CHENNAI METROPOLITAN DEVELOPMENT AUTHORITY
Thalamuthu Natarajan Building, No.1, Gandhi Irwin Road, Egmore,
Chennai - 600 008
Phone : 28414855 Fax: 91-044-28548416
E-mail: mcmda@tn.gov.in
Web site: www.cmdachennai.gov.in

Letter No. C3(N)/19019/2016, dated .04.2017

Sub: CMDA – APU – MSB (North) Division – Planning Permission Application for the proposed construction of Multi-storied Group Development building consisting of 2 Blocks commercial cum residential use, at Block No. 1 - G.Floor + 1st Floor + 2nd Floor (Commercial use) + Service Floor and 3rd Floor to 12th Floor (Residential use with 60 dwelling units) and Block (Amenity Block) No. 2 - Stilt Floor + 4Floors (Stilt + 1st & 2nd Floor for Puzzle Parking up to 8.40 m height accommodating 17 Nos of car parking and Gym & Multipurpose Hall at 3rd & 4th Floor) at rear side. In survey No. 219/ 2A, 2B1B & 24 of Kattupakkam Village, Poonamallee High road, Chennai, within the limits of Poonamallee Panchayat union - Applied by **M/S. Pooja Foundation Pvt Ltd (Rep. by its Director B. Budhmal Bohra) & Others, (GPA Holder)** - Proposal placed before the MSB Panel - Recommended and forwarded to Government for Approval –Reg.

DRAWING TITLE:
BLOCK - 2 : AMENITY BLOCK - FLOOR PLAN

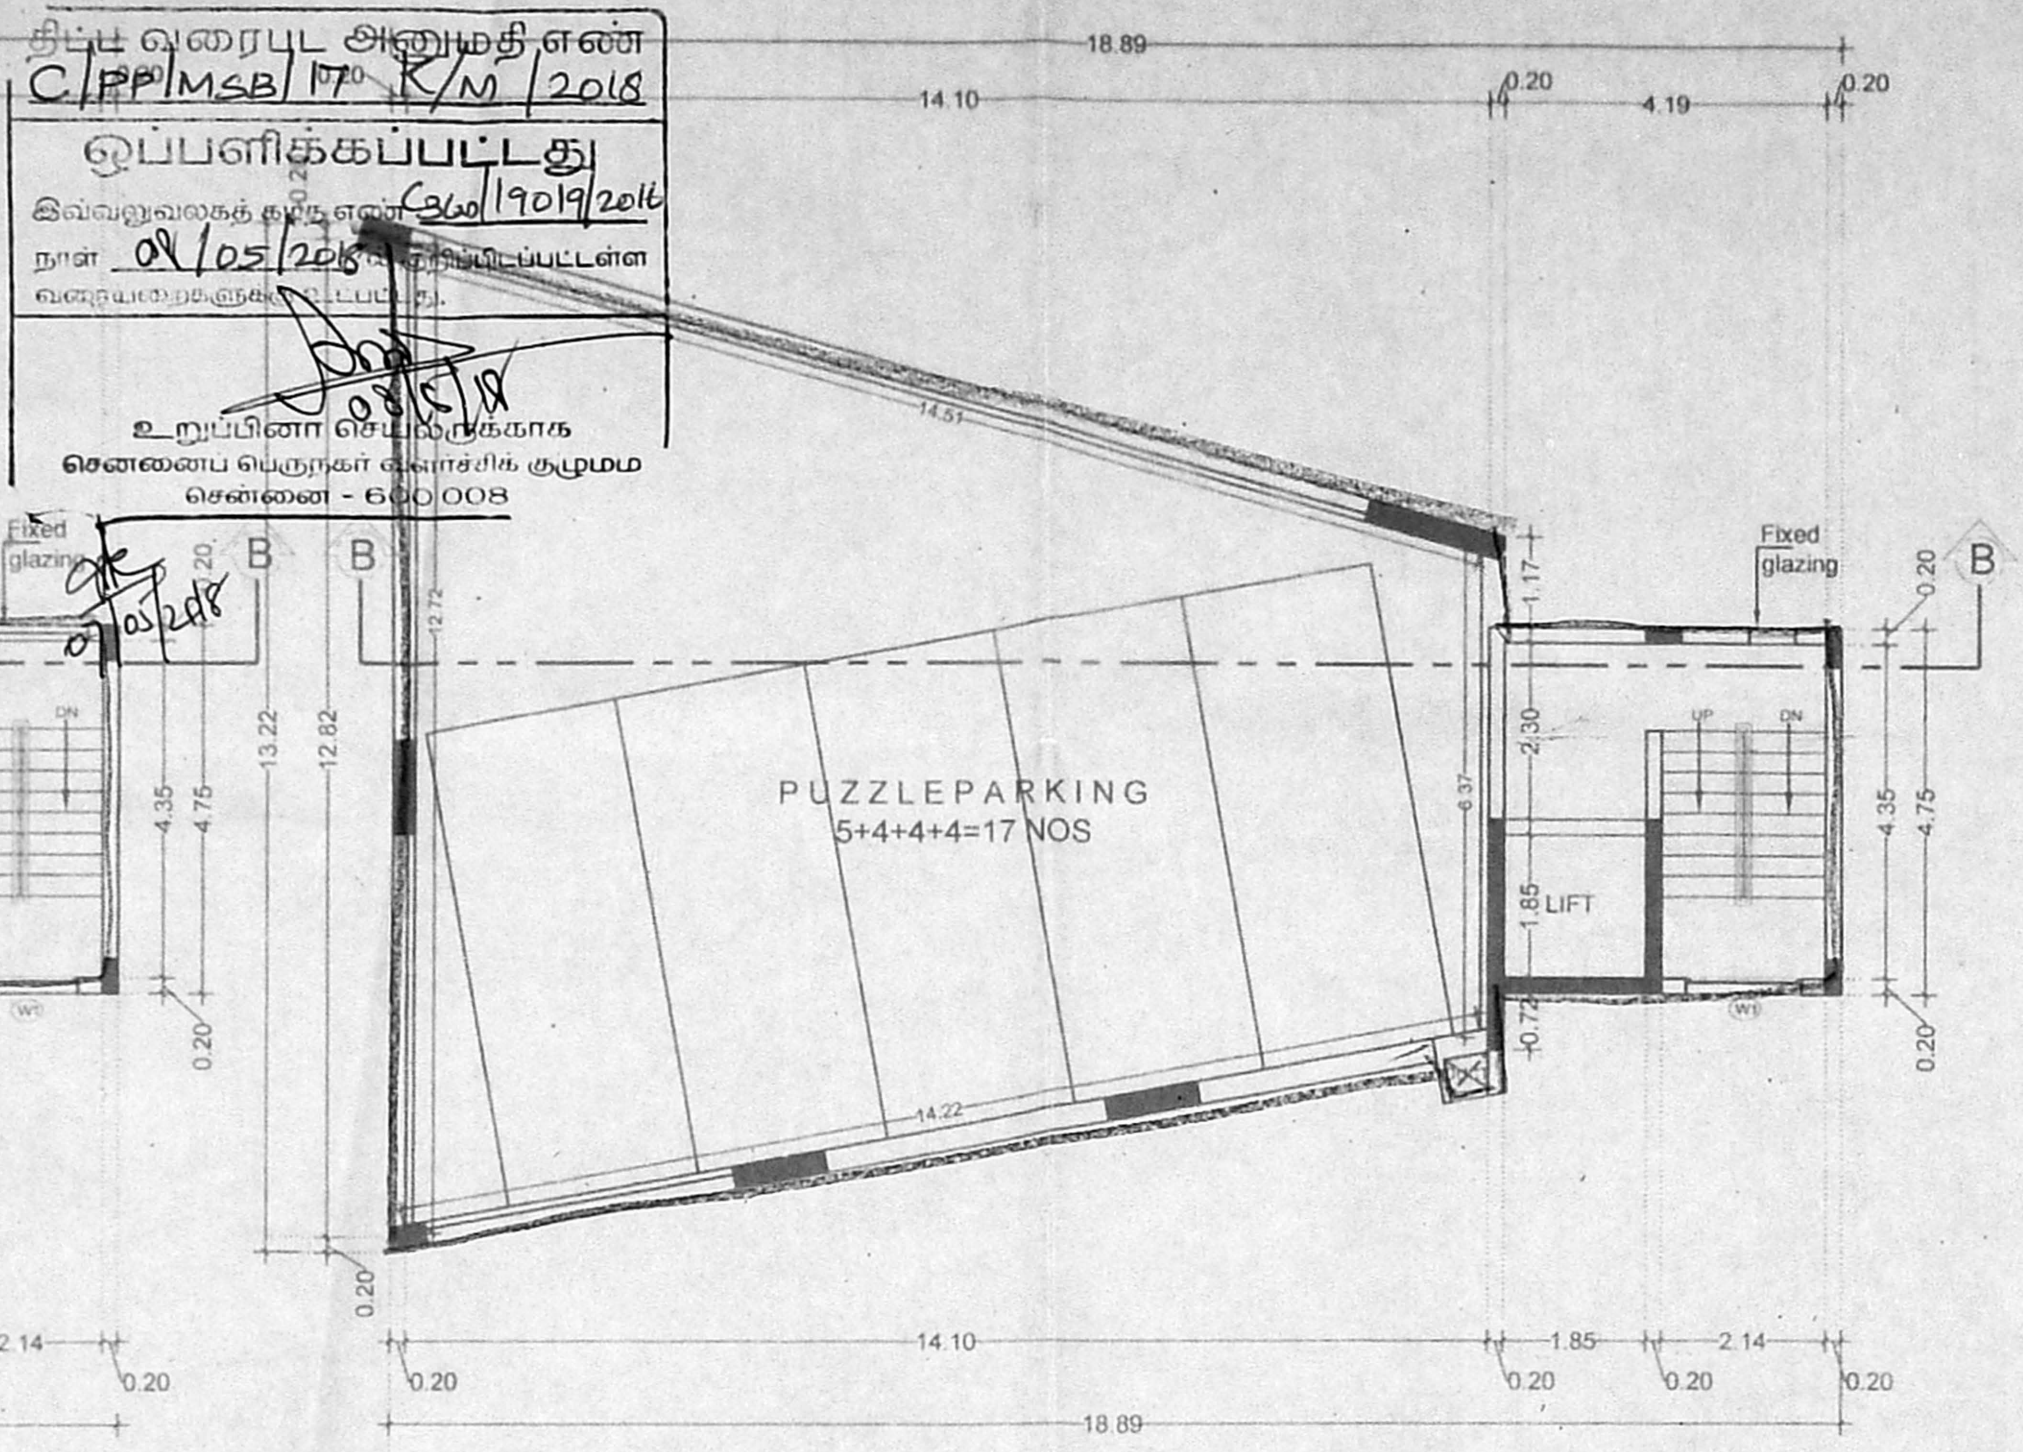
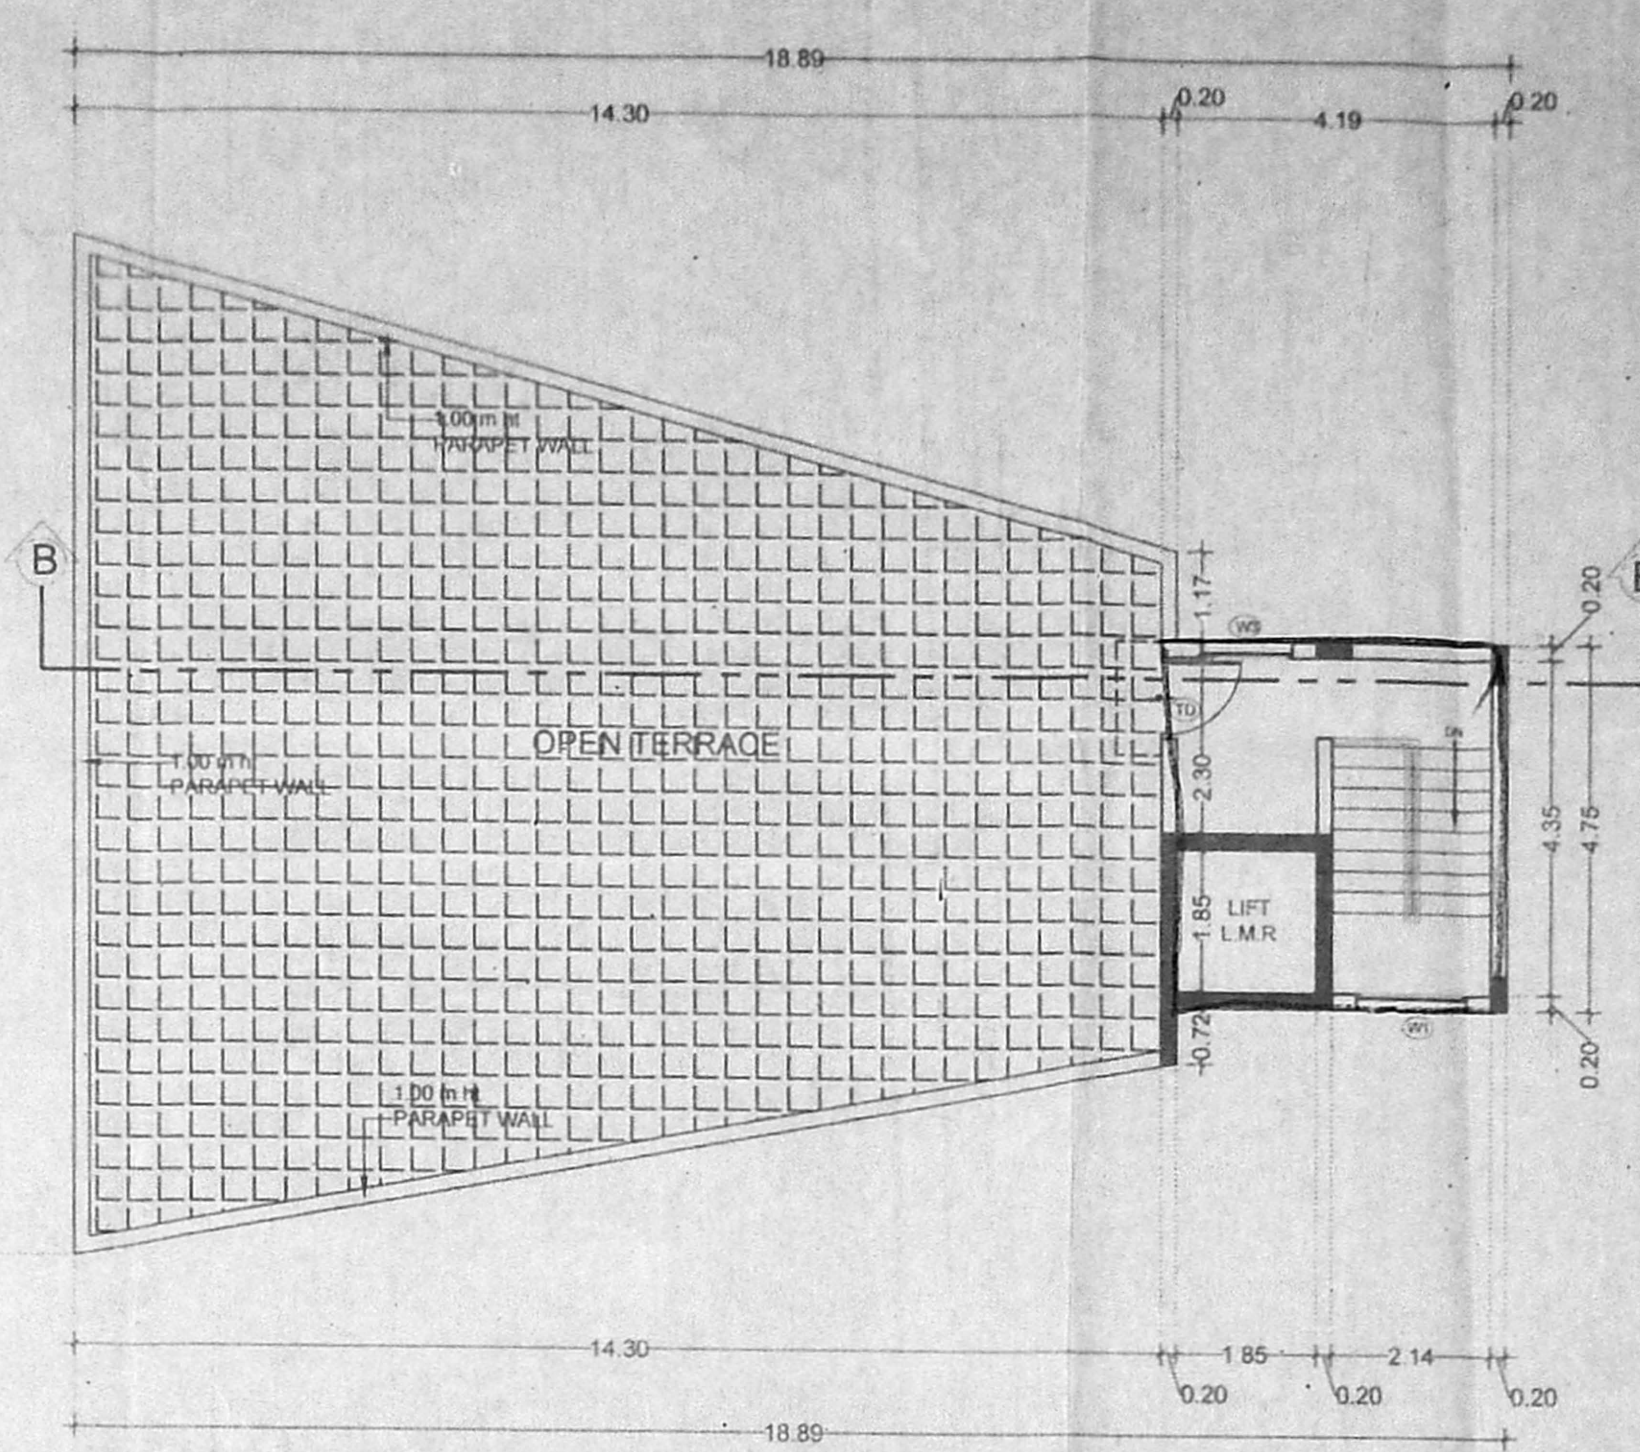
6. In stilt floor entry/exist to the puzzle parking to be shown properly.
7. Existing H.T. Line alignment as per the site conditions to be marked in the FMB duly signed by the revenue official not below the rank of deputy tahsildar to be furnished. Accordingly the H.T.Line to be shown in the site plan.

25. OHT for Fire water, sullage water & Rain water purposes are also to be shown.
26. Enclosed wall shown around stilt floor to be removed.
27. Total height to be shown for Amenity block in elevation & cross section.
